Our Ref: PLAN-001676

22/11/2012

**Proposal: Erection of 2 no. 2 bed dwellings and 1 no. 3 bed dwelling and formation of 3 no. parking spaces.**

**Site: 28 & 30 Corbishley Road, Bognor Regis, West Sussex PO229HR.  
BR/266/12/**

REVISION			
PROJECT			
Proposed residential development at Cortishley Road, Bognor Regis			
SUBJECT			
Block Plan and Location Plan			
SCALE	DATE	DRAWING NO.	
1:200/1:1250	June 2012	2012 / 19 / 02	
DRAWN	CHECKED

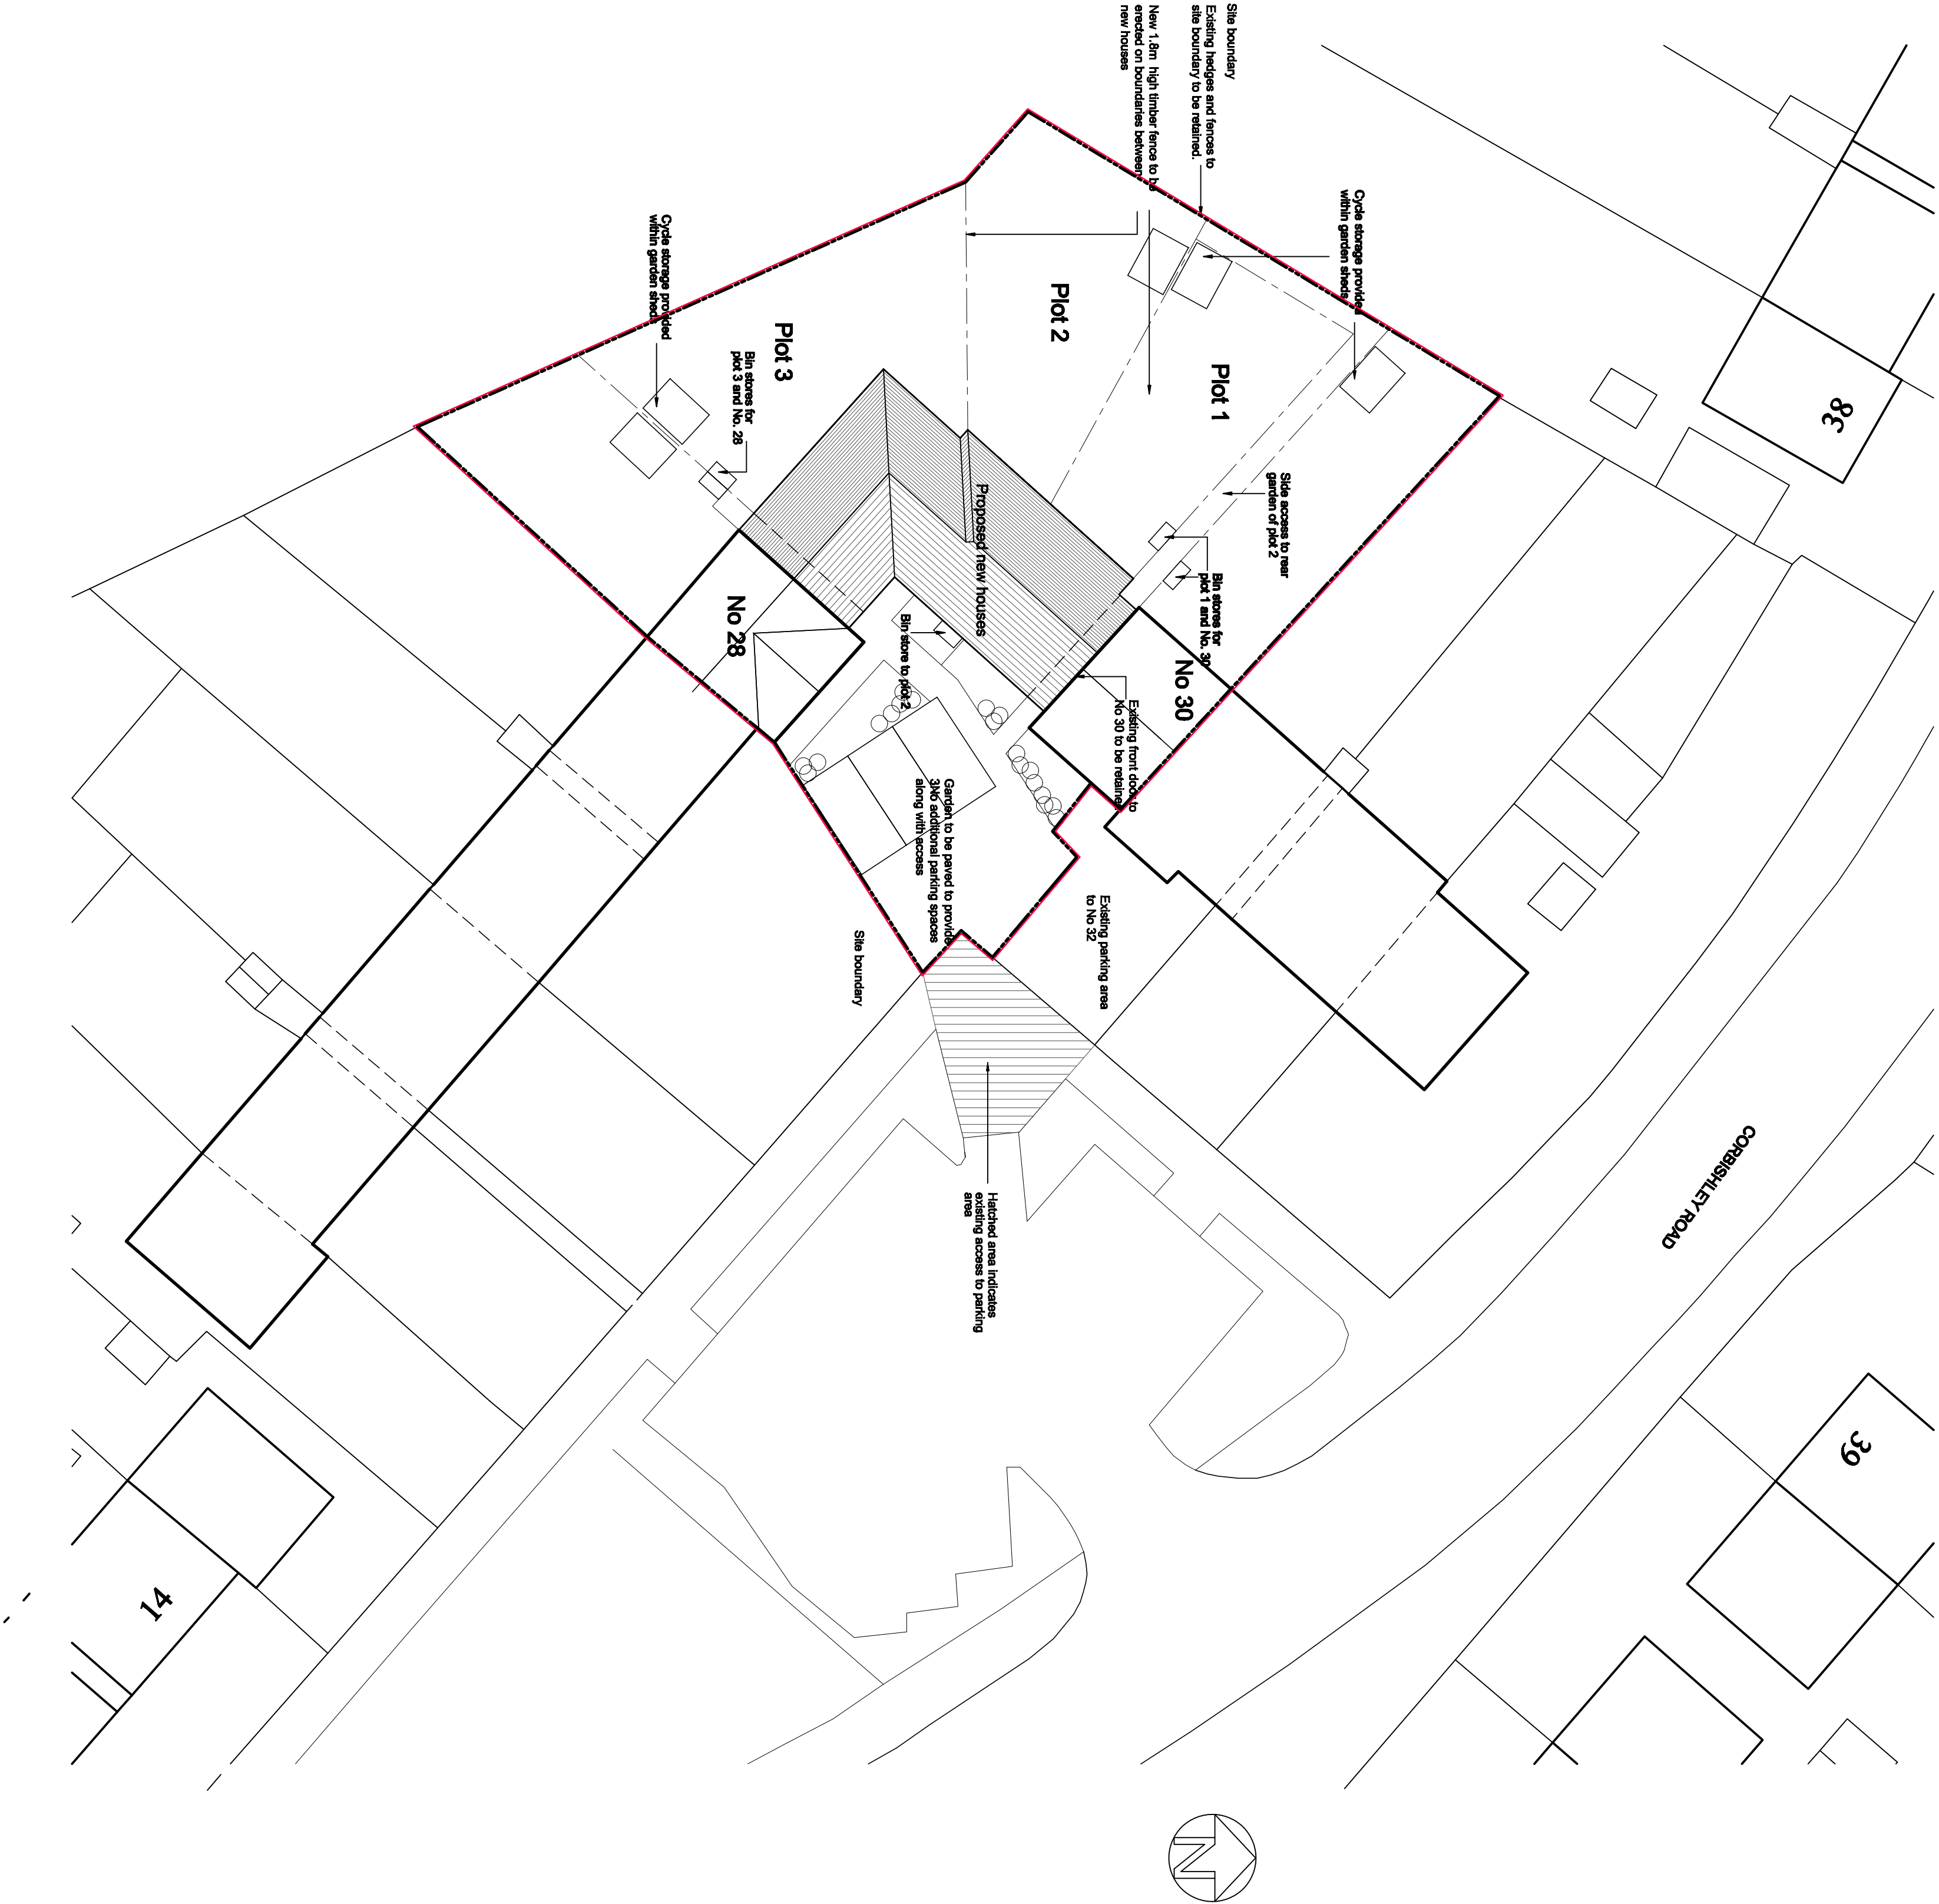
Please find attached a plan of the sewer records showing the approximate position of a public sewer in the access road. The exact position of the public sewers must be determined on site by the applicant. Please note:

No development or new tree planting should be located within 3 metres either side of the

centreline of the public sewer and all existing infrastructure should be protected during the course of construction works.
